## Application for non-material amendment following a grant of planning permission

Two story side and rear extension

DM/2020/01467

Swap side window with door into hallway and alter a small section of the planned roof above the stair well to become flat instead of pitched.

Proposed side

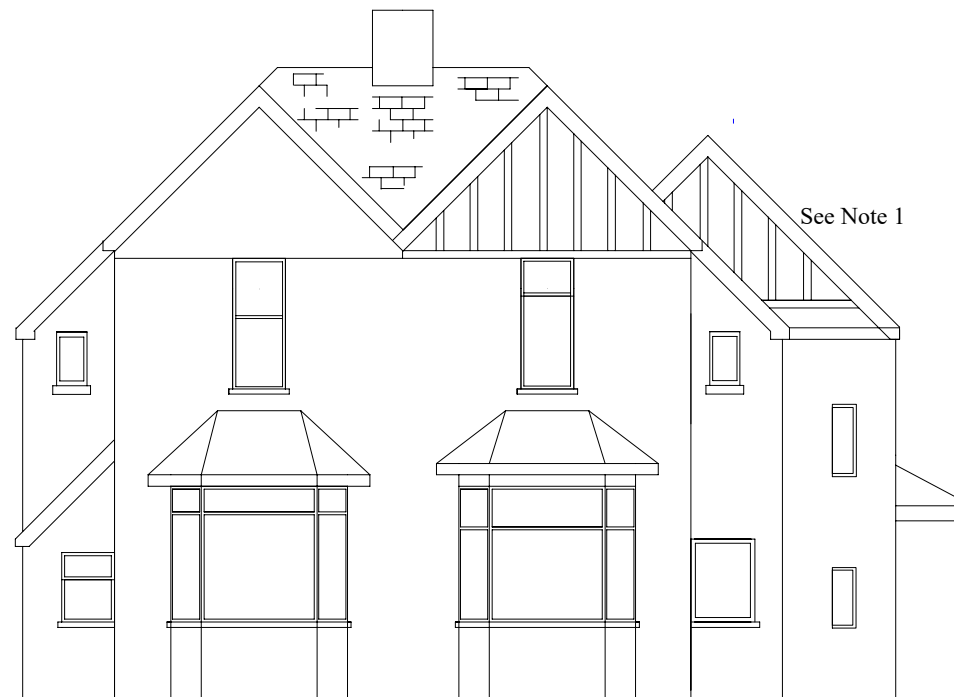
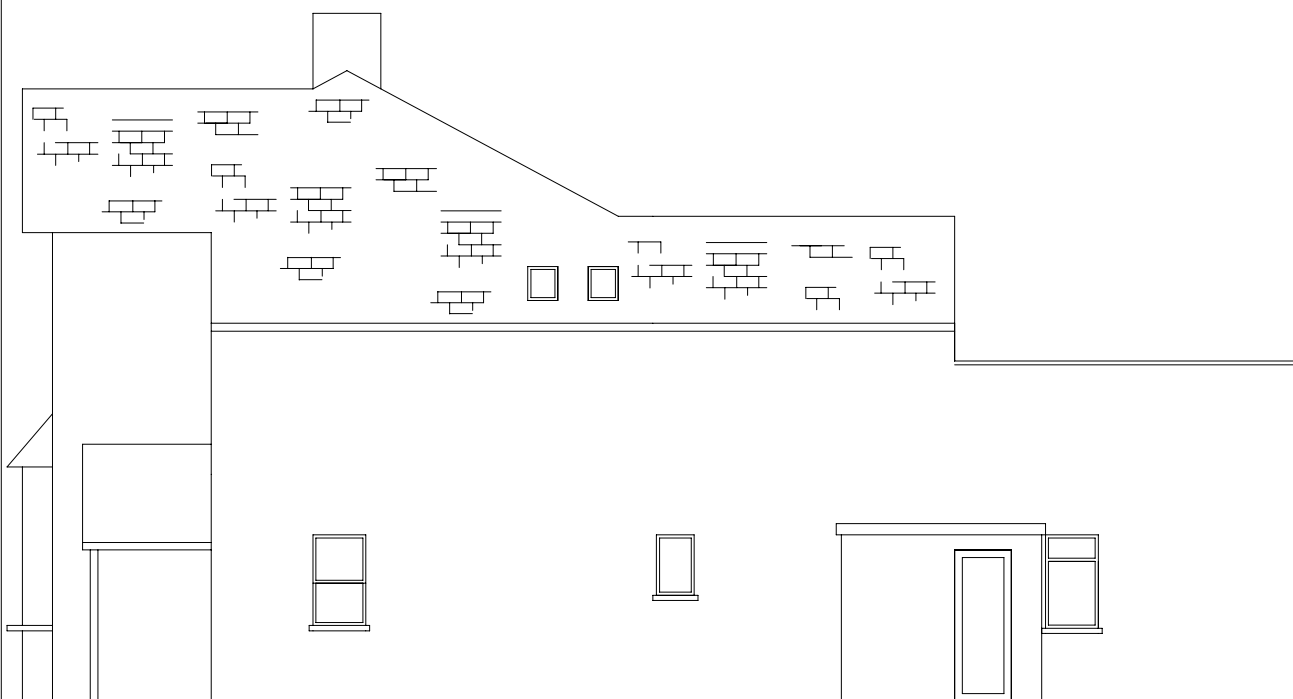
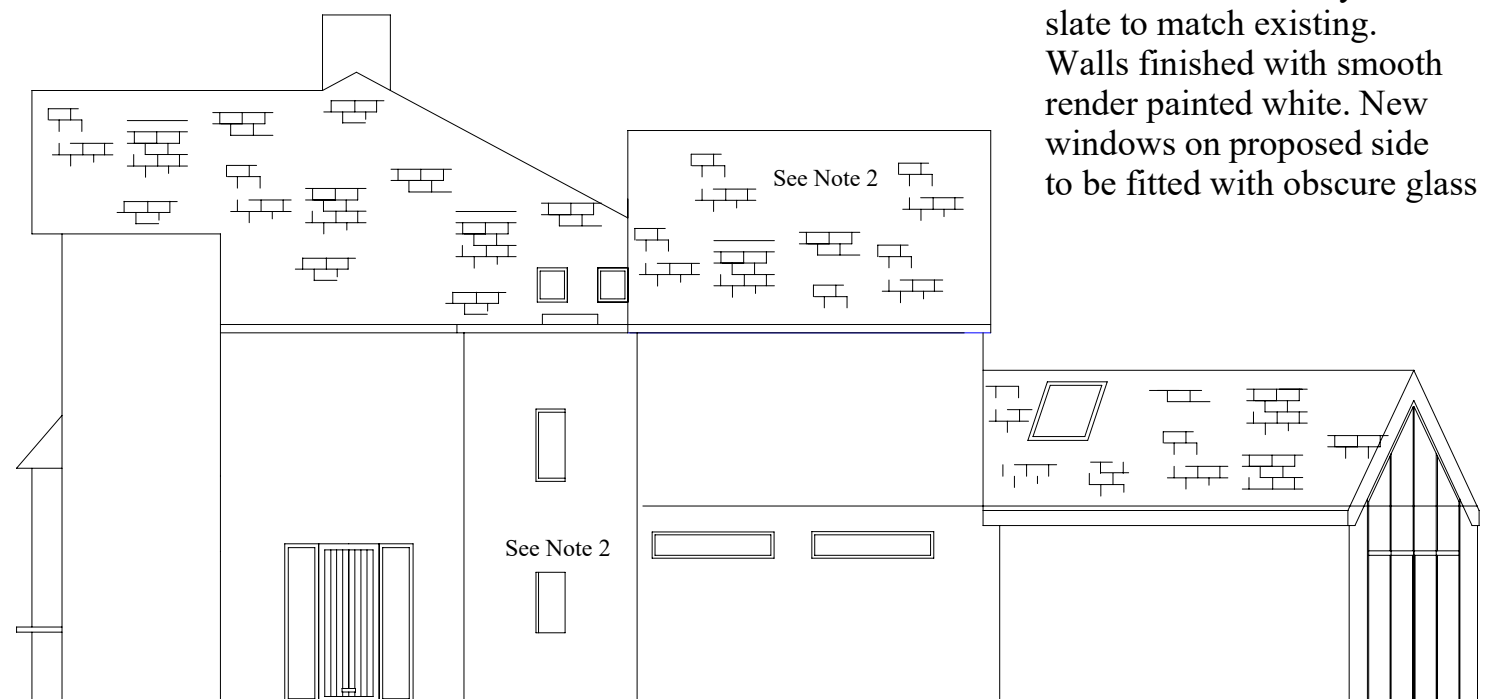
The alteration of the roof section will allow for greater head height on the stairwell and will also keep the external roof lines & gutter running continuously around the building at the same height keeping the exterior more simple and streamlined.
